on No.: 06DRB-01628 (P&F)	Project # 10	04602
	ALVARADO GARDENS NO. 2		
Agent: Doug	Smith	Phone No.:	255-5577
approved on _	or (SDP for SUB), (SDP for BP), (FIIIIIIIIIIIIIIIIIIIIIIIIIIIIIIIIIIII	gation of signat	ure(s) to the following departments.
TRÂN	SPORTATION:		
UTILI	ΓIES:		
CITY CITY	ENGINEER / AMAFCA:		
PARKDD	S / CIP:		
PLAN		skf mficuries	on 2 easements
	County Treasurer's signature mu with the County Clerk.	reasurer. the County Classor. Include all ust be obtained.	Clerk. erk). RECORDED DATE: pages. d prior to the recording of the plat ained prior to Planning Department's

DEVELOPMENT REVIEW BOARD ACTION SHEET

16. Project # 1004602 — 06DRB-01628 Minor-Prelim&Final Plat Approval

DOUG SMITH agent(s) for ROBERT JENKINS request(s) the above action(s) for all or a portion of Lot(s) G & westerly portion of Lot(s) F, ALVARADO GARDENS NO. 2, zoned RA-2, located on CASTANEDA RD NW, between ORO VISTA RD NW and CAMPBELL RD NW containing approximately 1 acre(s). [REF: 06DRB-01098 (G-12) THE PRELIMINARY AND FINAL PLAT WAS APPROVED WITH FINAL SIGN OFF DELEGATED TO PLANNING FOR AGIS DXF FILE, MAINTENANCE AND BENEFICIARIES OF THE 2 EASEMENTS AND TO RECORD THE PLAT.

OF  
 LOT G-1, G-2 & F-1  
 ALVARADO GARDENS SUBDIVISION  
 UNIT NO. 2  
 PROJECTED SECTION 1, TOWNSHIP 10 NORTH, RANGE 2 EAST, N.M.P.M.  
 TOWN OF ALBUQUERQUE GRANT  
 CITY OF ALBUQUERQUE, BERNALILLO COUNTY, NEW MEXICO  
 JUNE, 2006

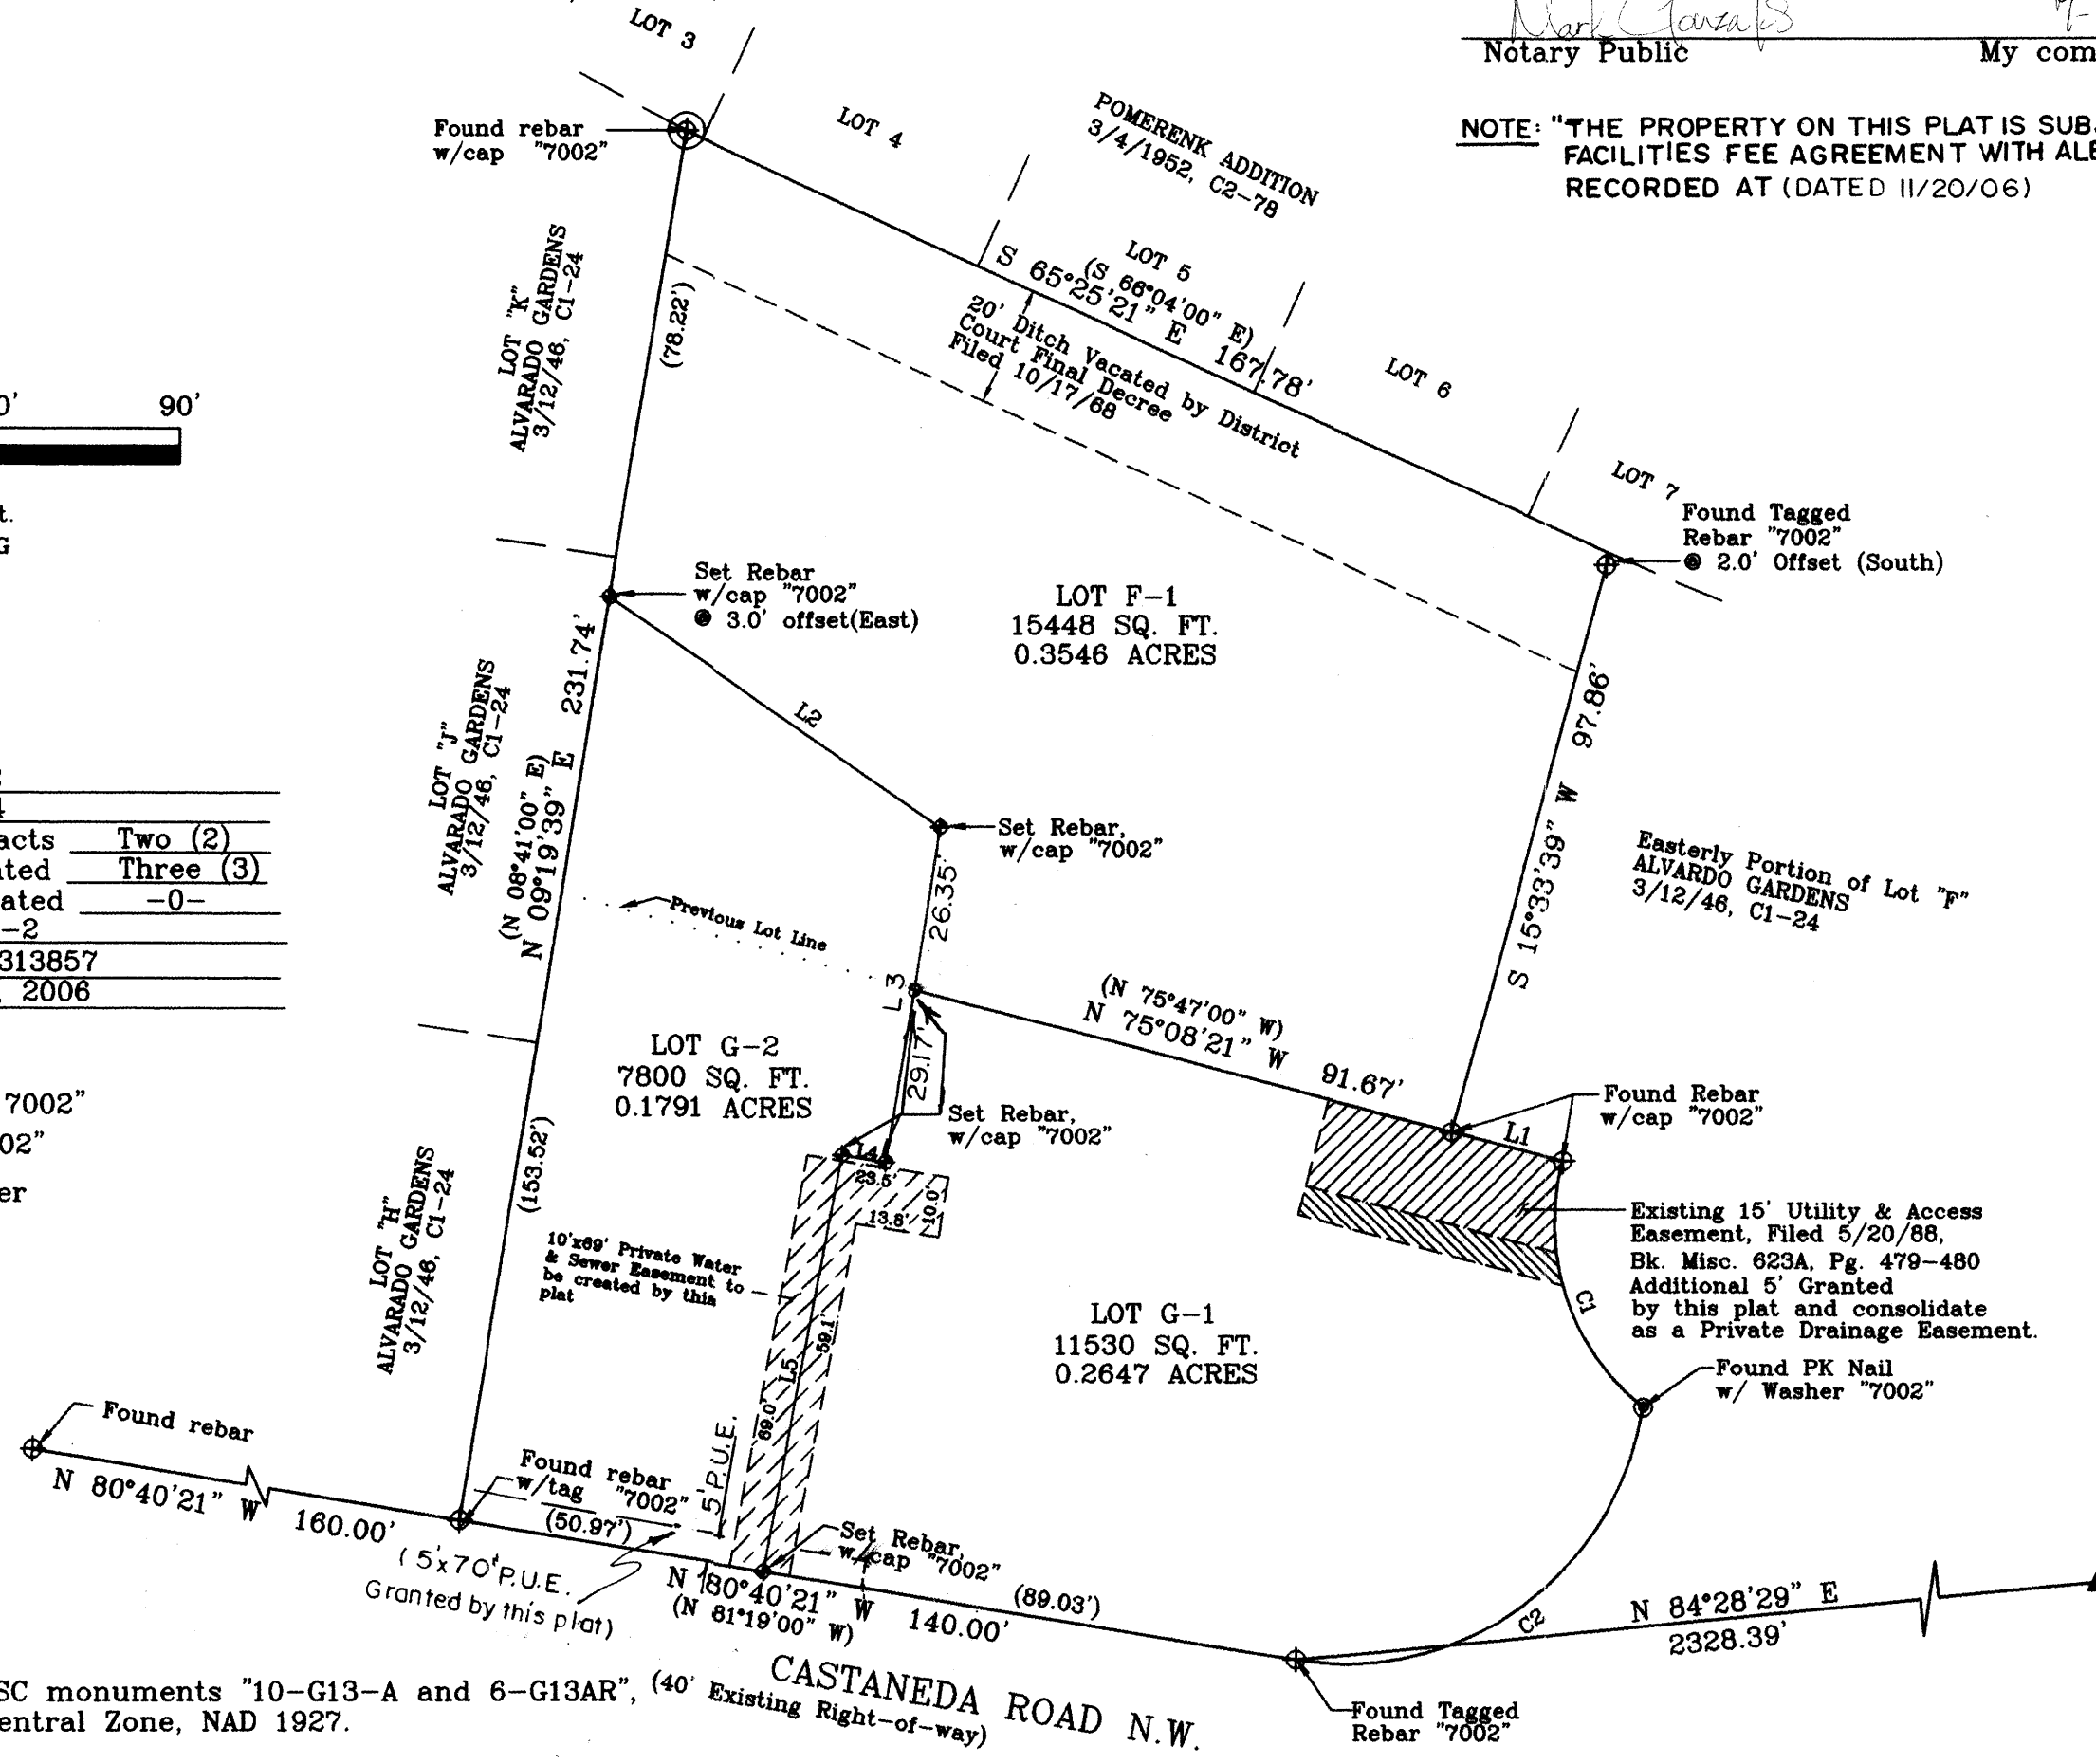
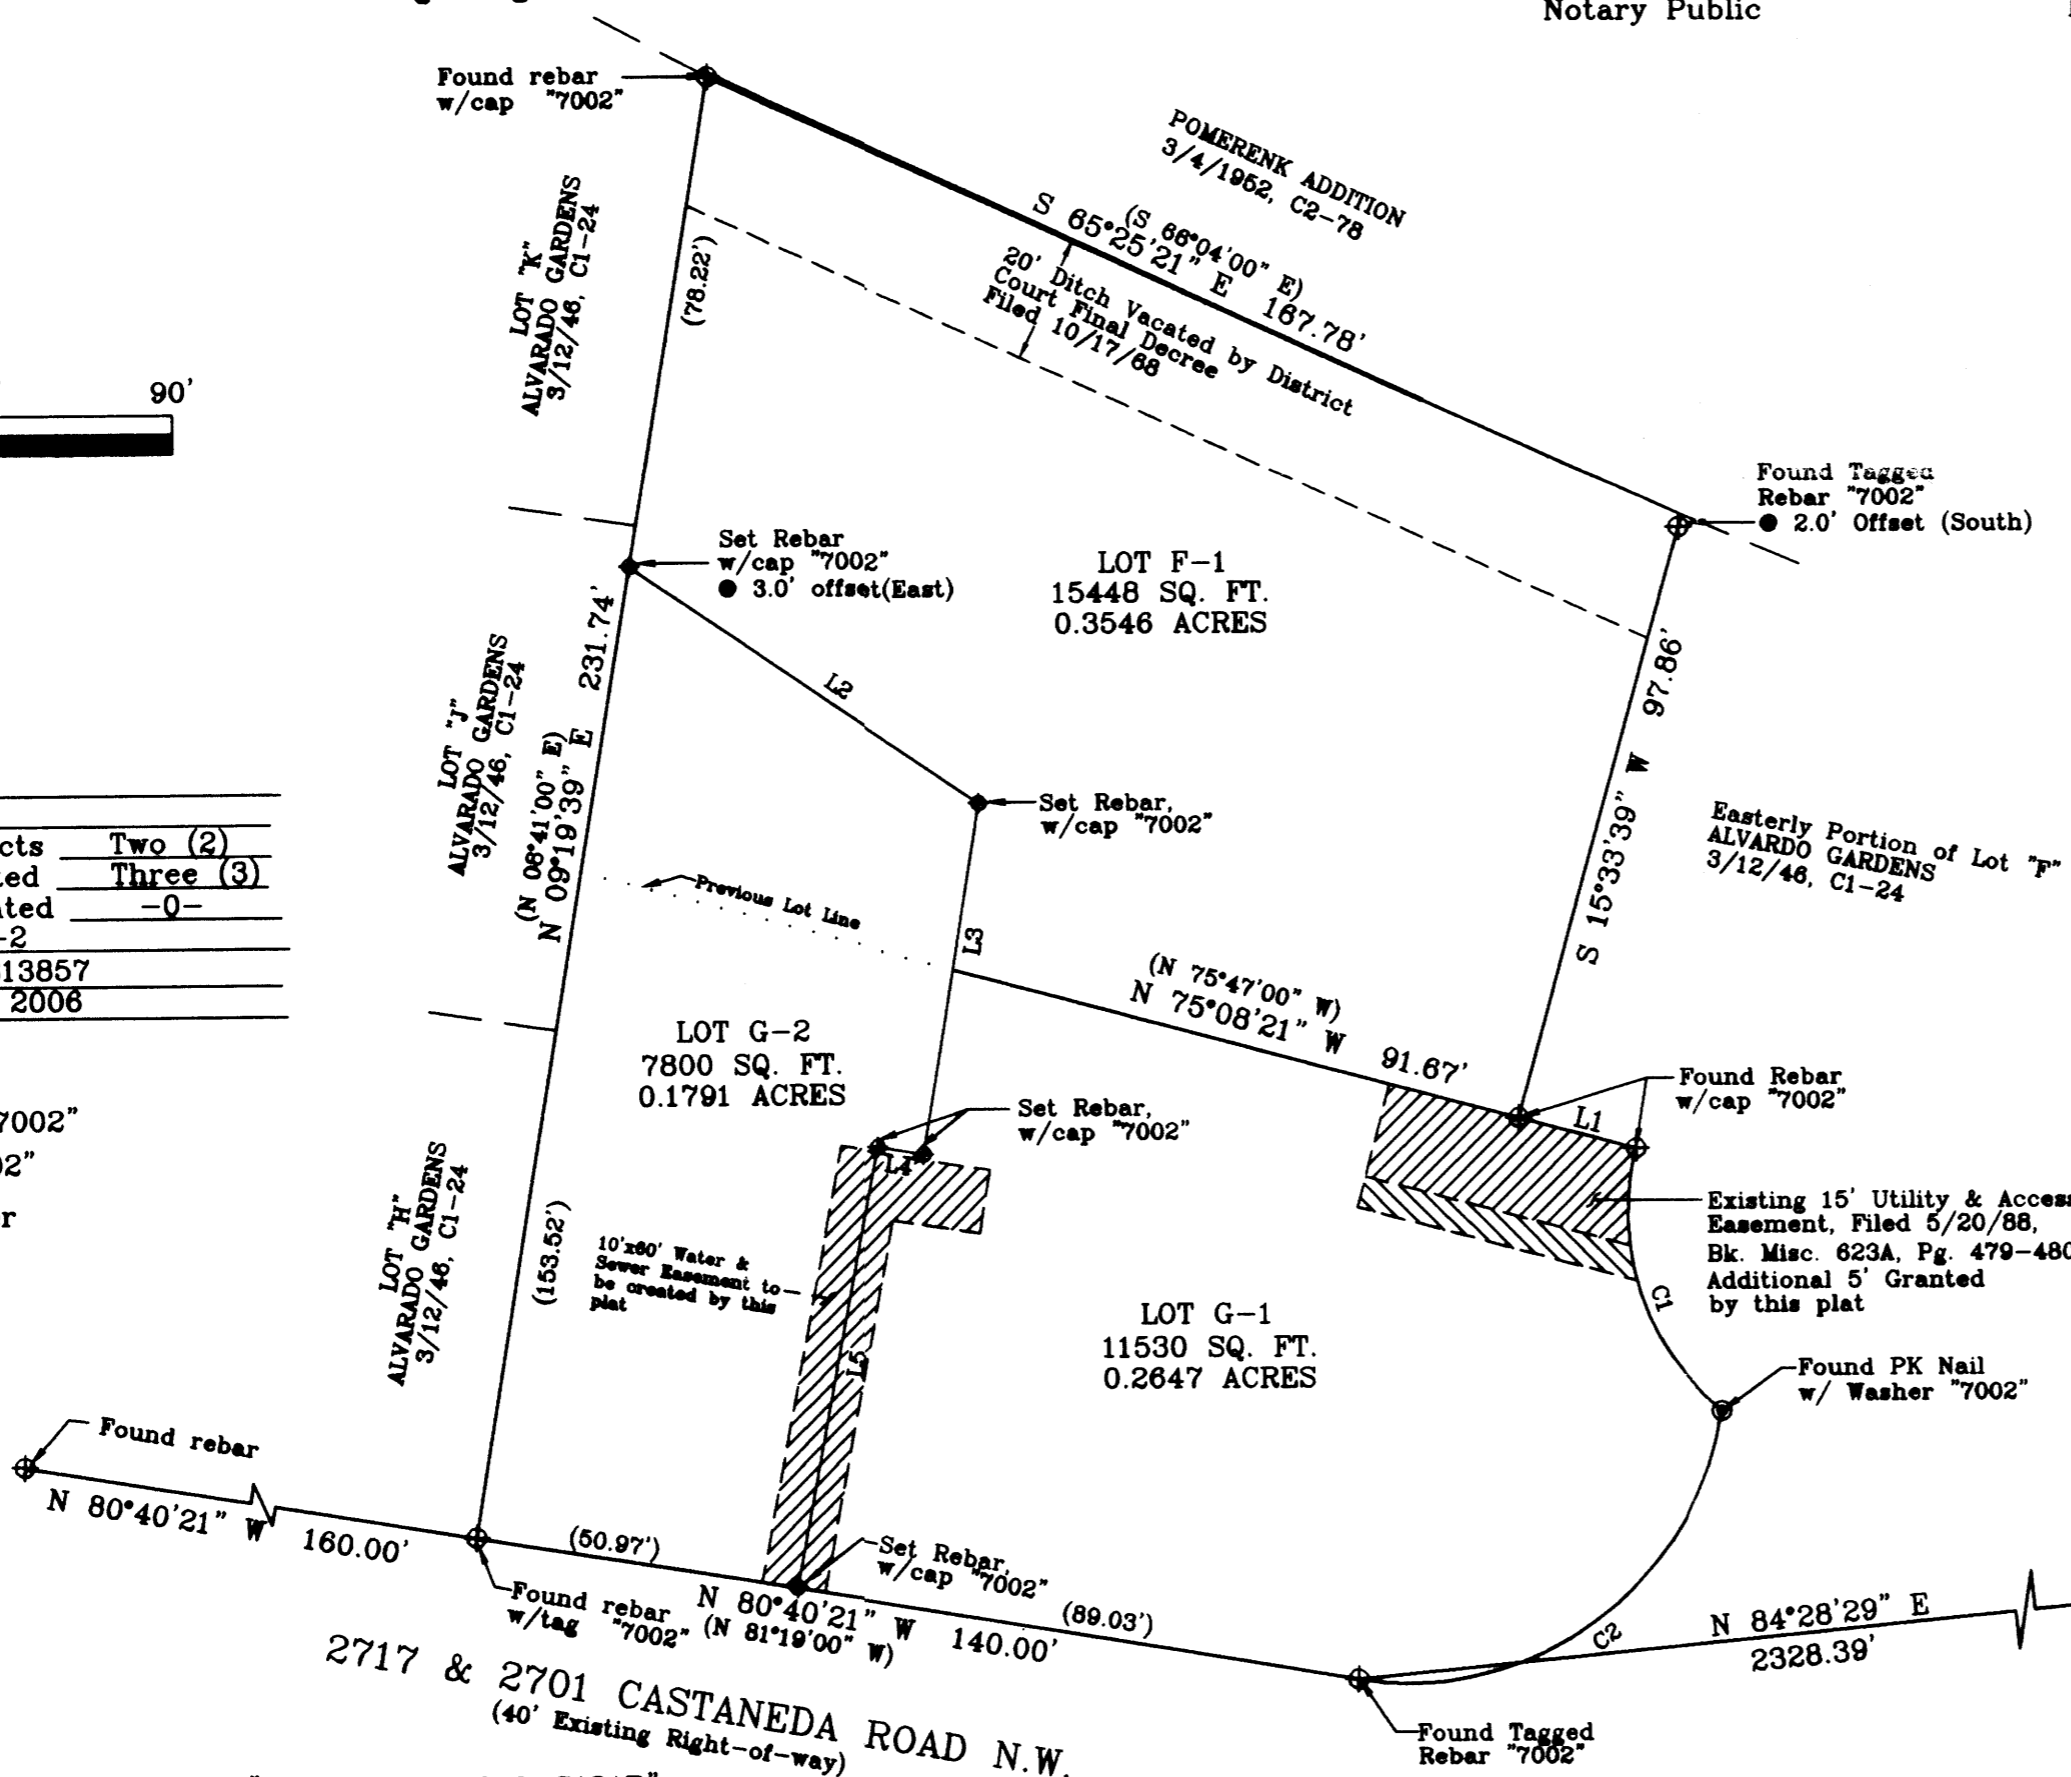
- 1) Applicant will need to provide a cross-section of the existing road improvements in relation to the right-of-way in order to evaluate infrastructure requirements.
- 2) Is there sidewalk?

Please clarify where the lot lines are on the sketch.

A special exception has been granted for lot width as well lot size. The sketch does not seem to agree with the granted exceptions.
